DOOLEY'S LIDCOMBE CATHOLIC CLUB - SSD 7603

COMMENTS FROM CUMBERLAND COUNCIL

Thank you for the opportunity to comment on the Concept Proposal for Tourist Related Purposes and Detailed Proposal for early works at Dooleys Lidcombe Catholic Club, Lidcombe, SSD 7603.

1 GROUND FLOOR PLAN
1 : 200

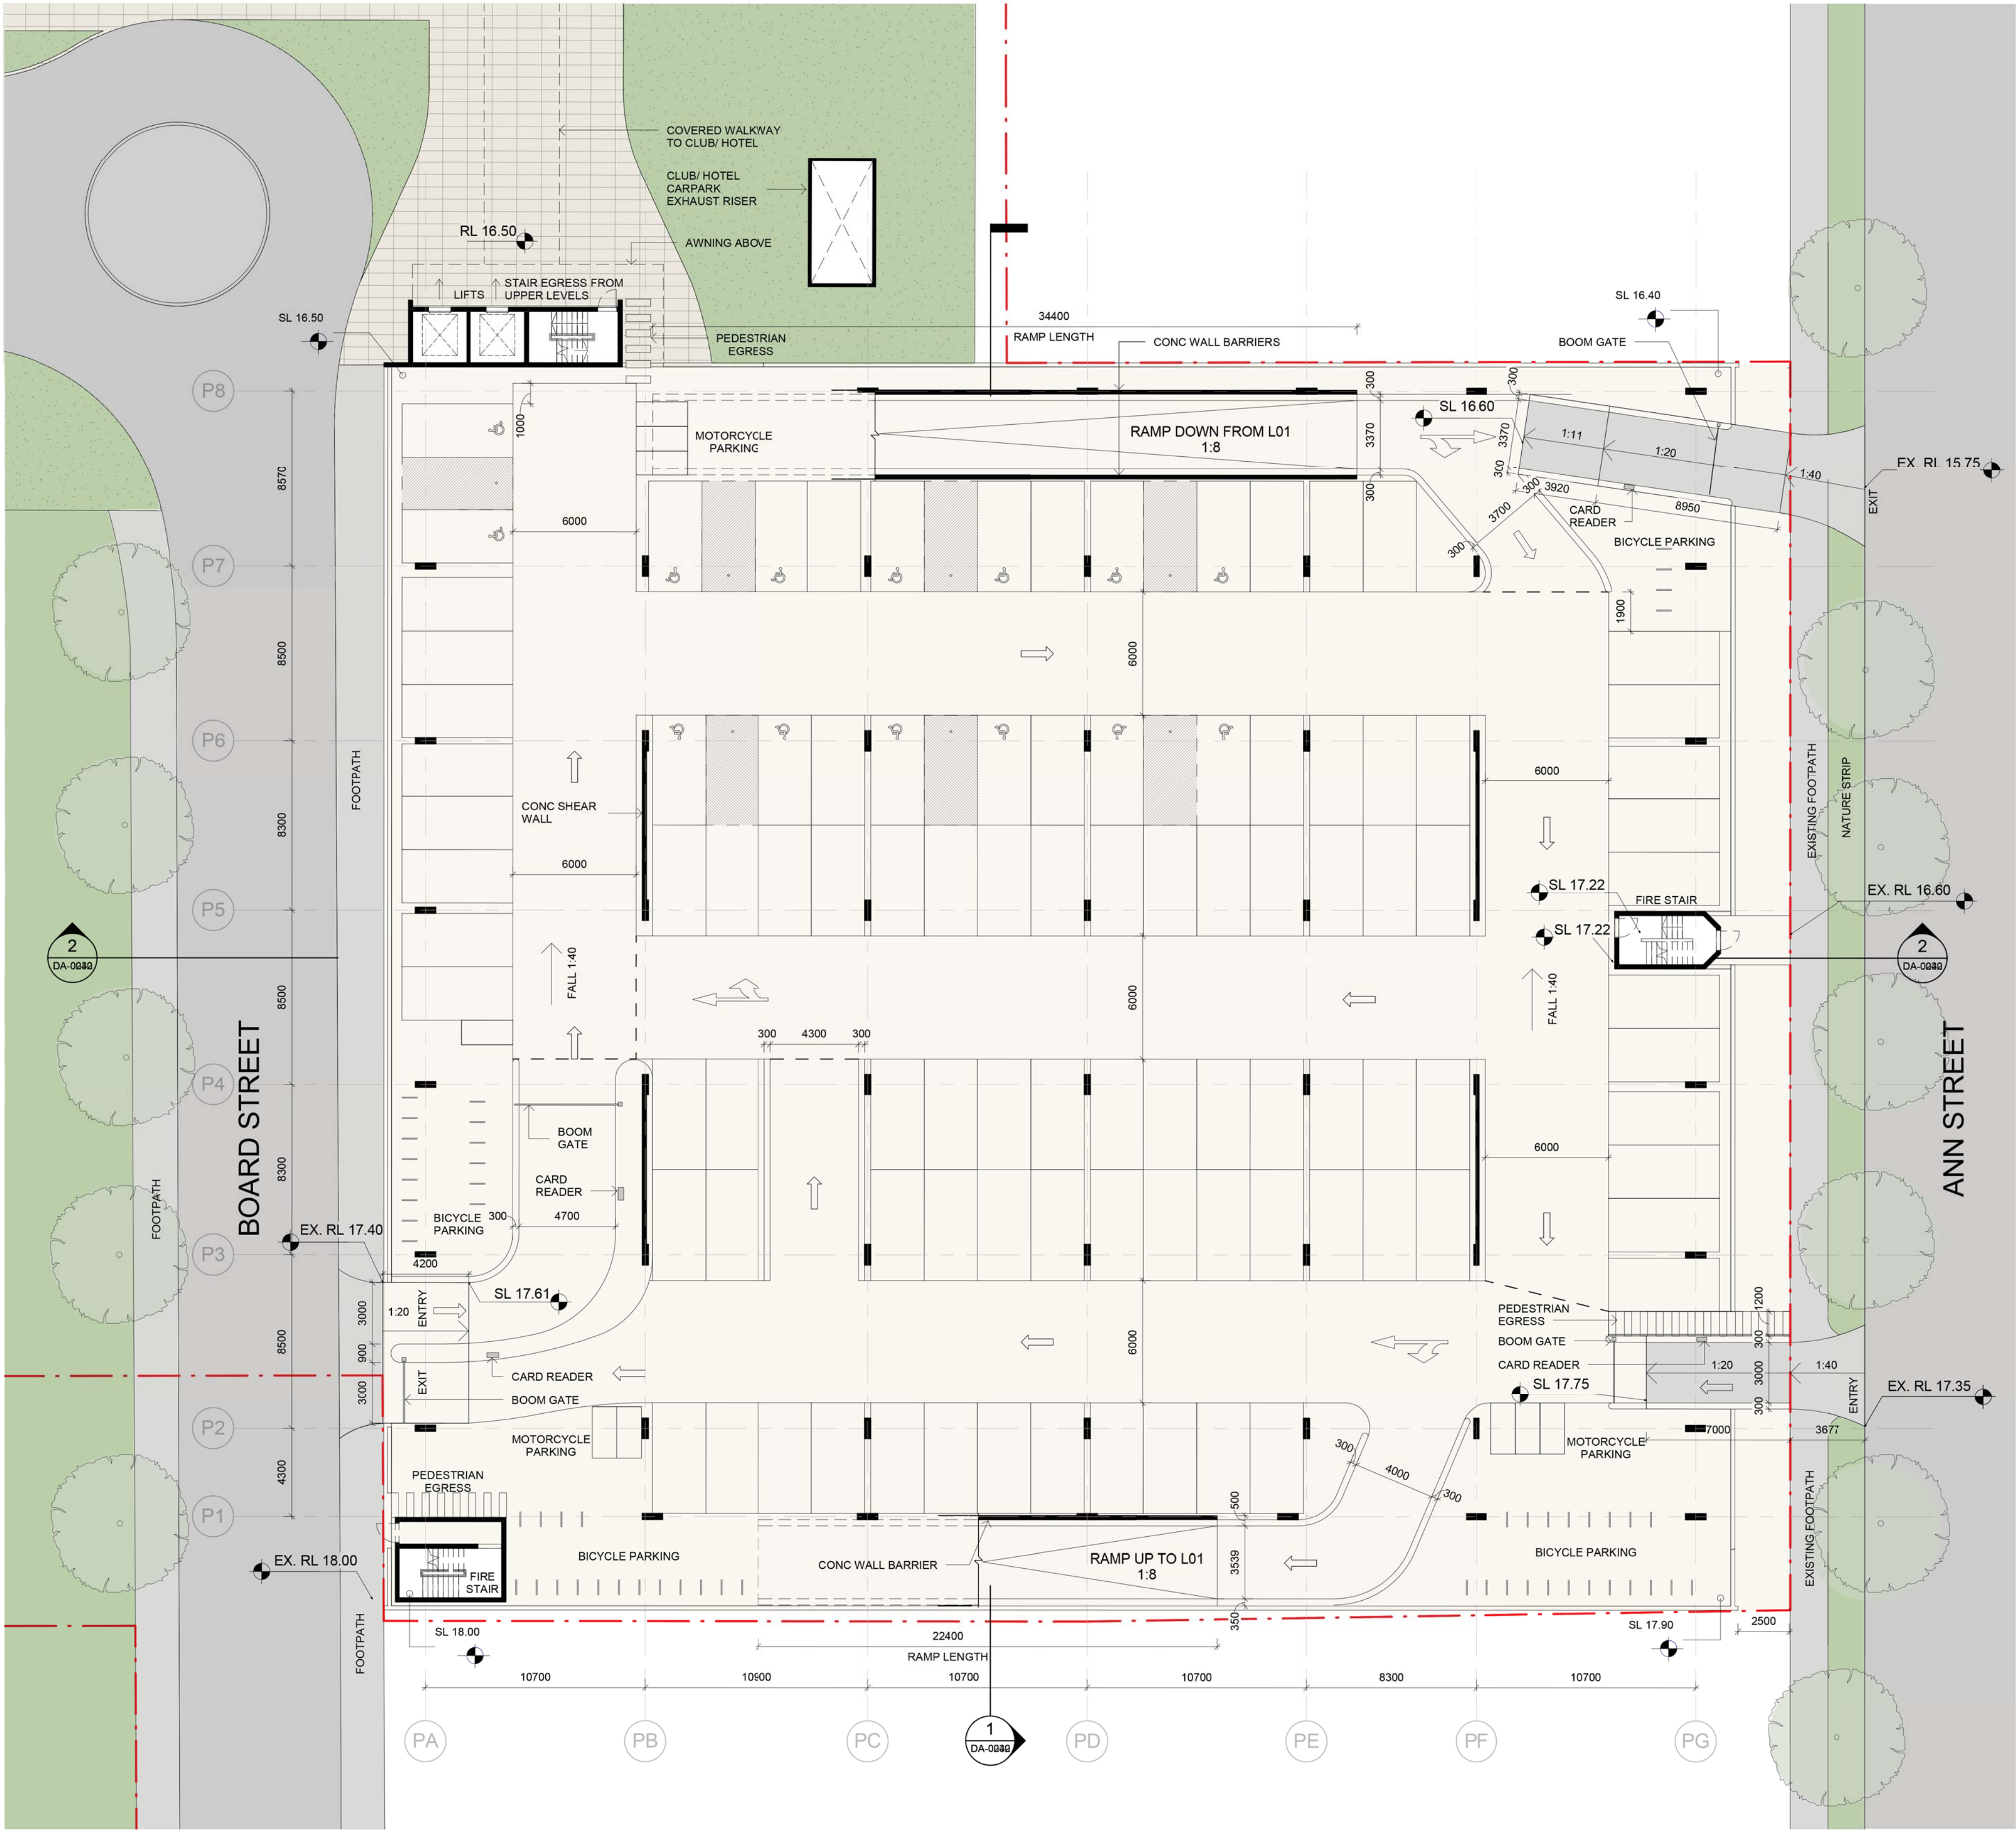
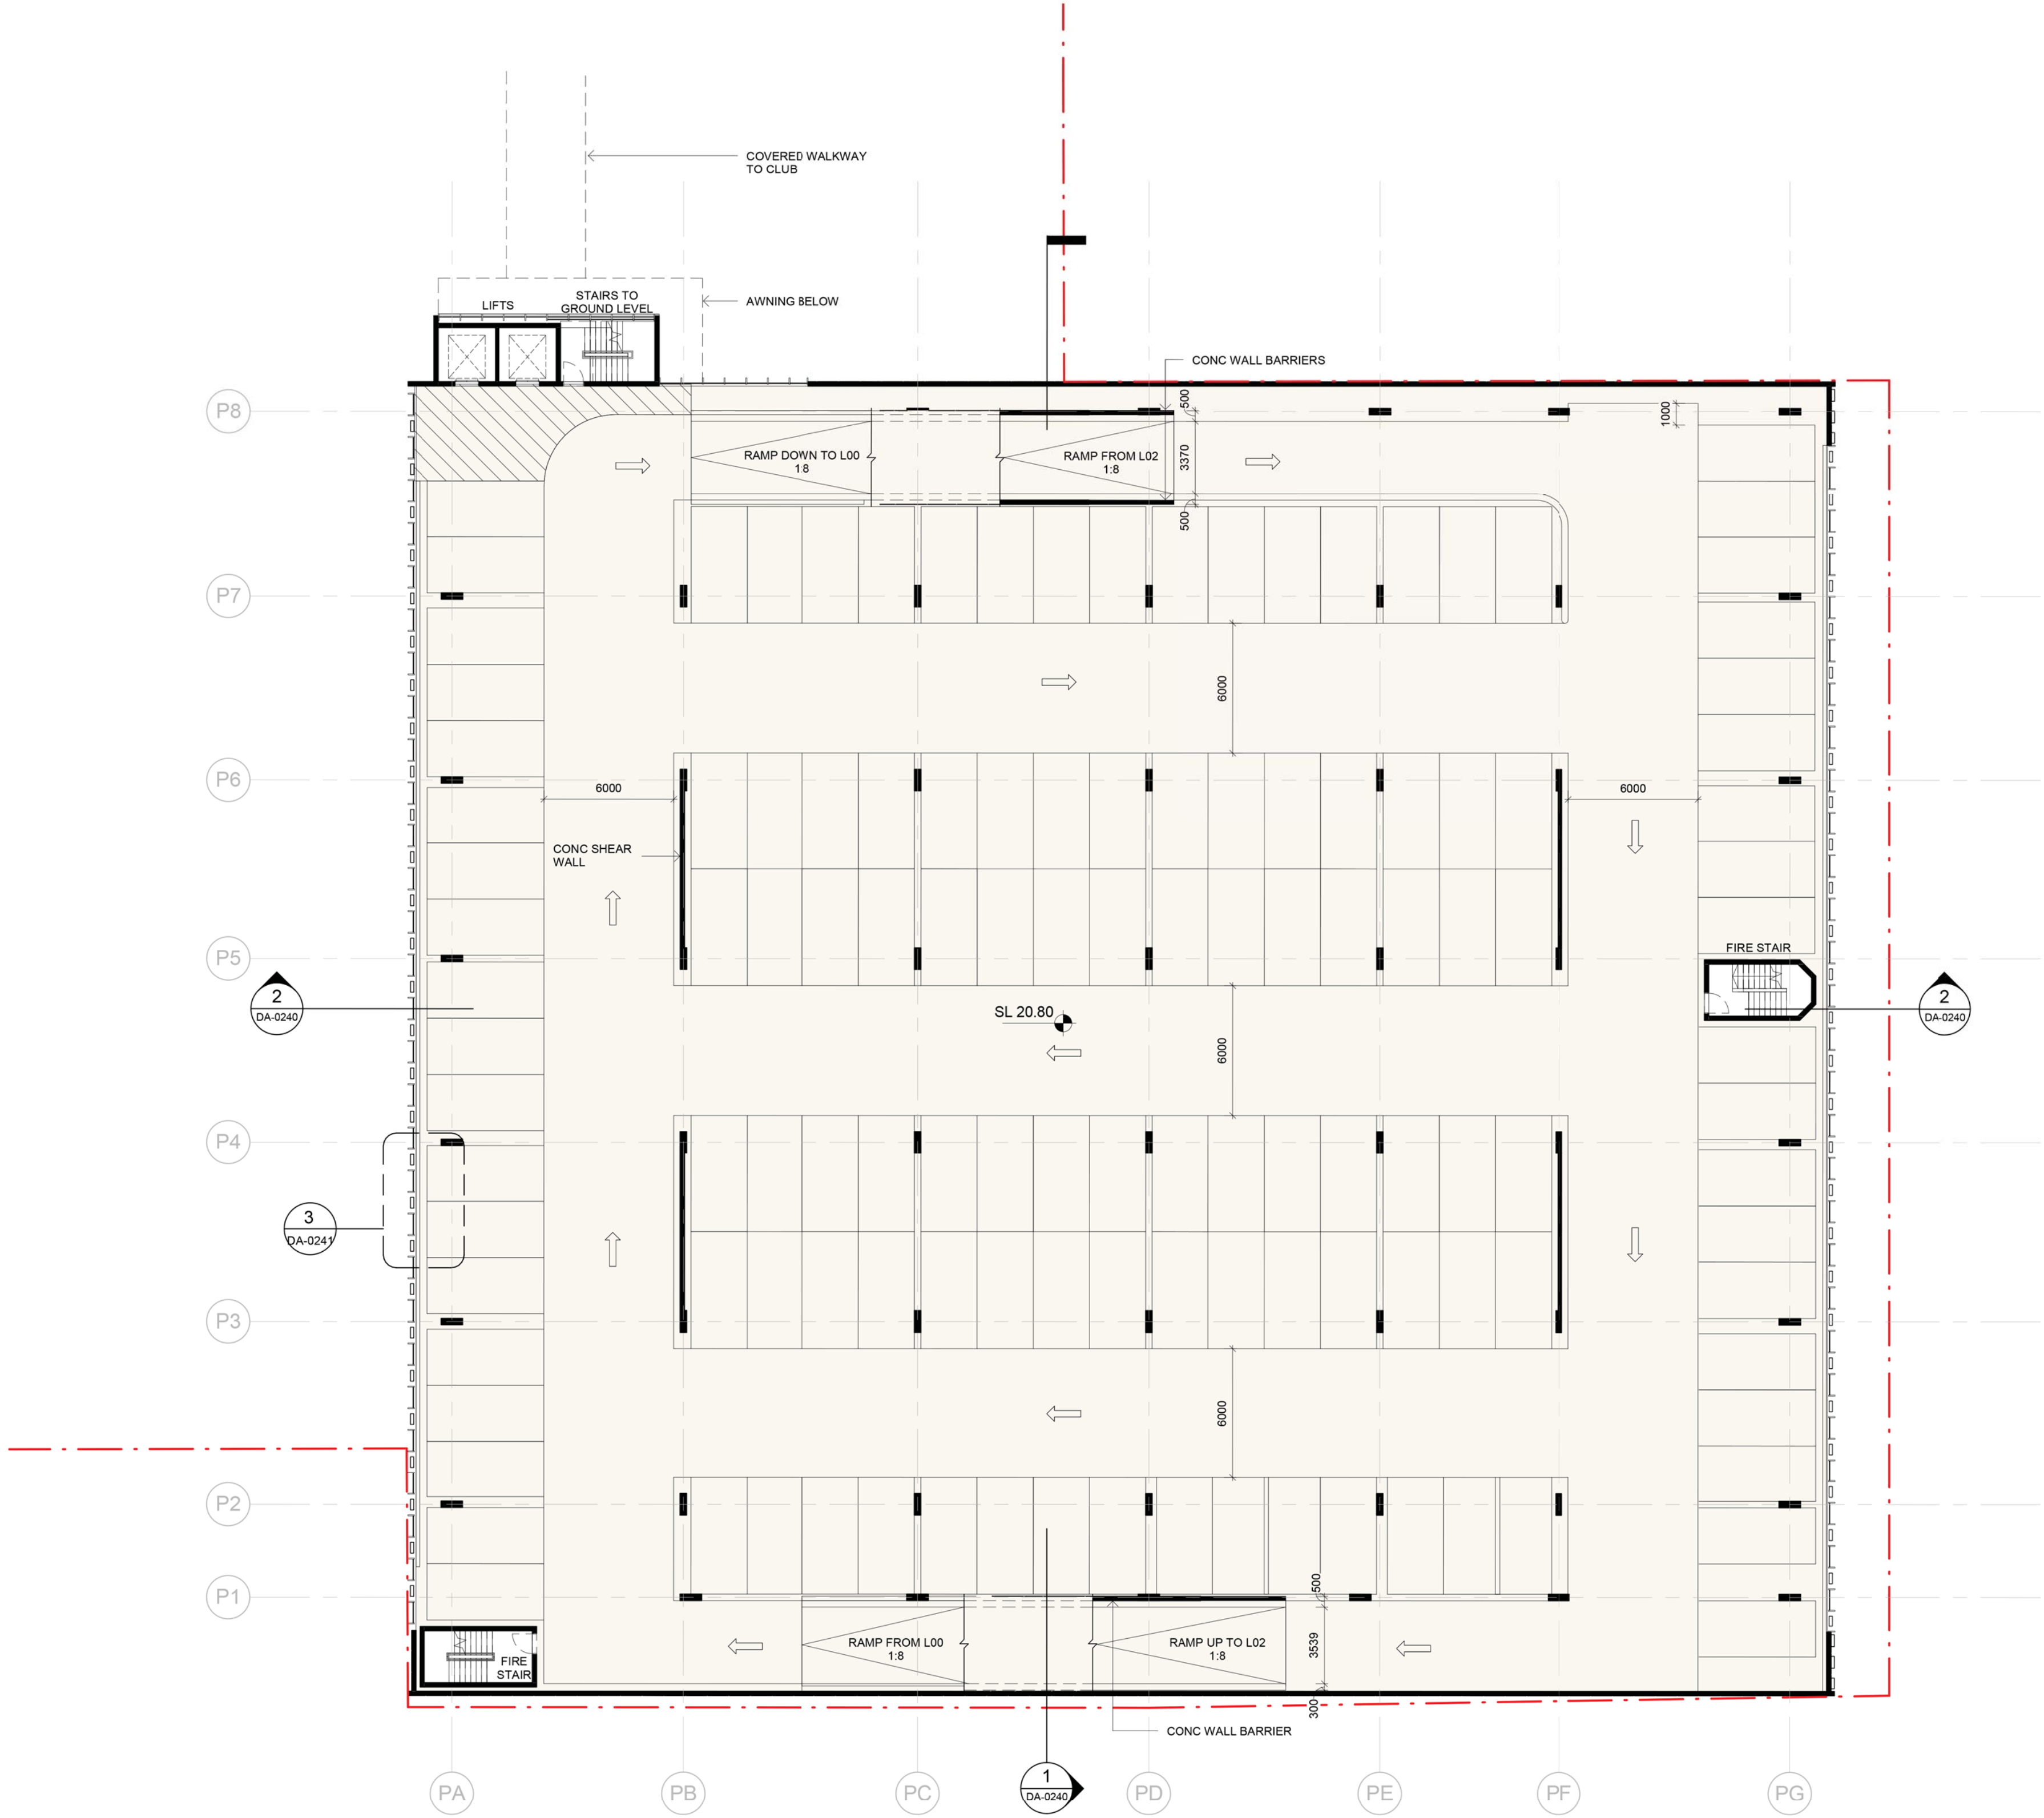
The requirements of *Built Form, Urban Design and Public Domain – Stage 1* of the SEARS do not appear to have been addressed in relation to the multi-storey car park. Discussion of alternatives to the above ground car park or provision for adapting the building for future uses, and activating the ground floor, could not be found in the documentation provided.

Council strongly recommends that there be adequate basement parking to address the requirements of the entire concept plan, without relying on above ground car parking. Should the Department nevertheless accept the concept of a permanent above ground car park in the future commercial area of the town centre, it is requested that:

- a. The structure be sleeved in active uses along Board St to support a vibrant active Lidcombe centre, eg small professional offices
- b. That some of the parking within the structure be provided at basement level

- c. That the building be substantially setback from Ann St, with deep soil landscaping including trees in the frontage to the site (eg 4-6m)
- d. That there be a substantial landscaped setback to the isolated sites:
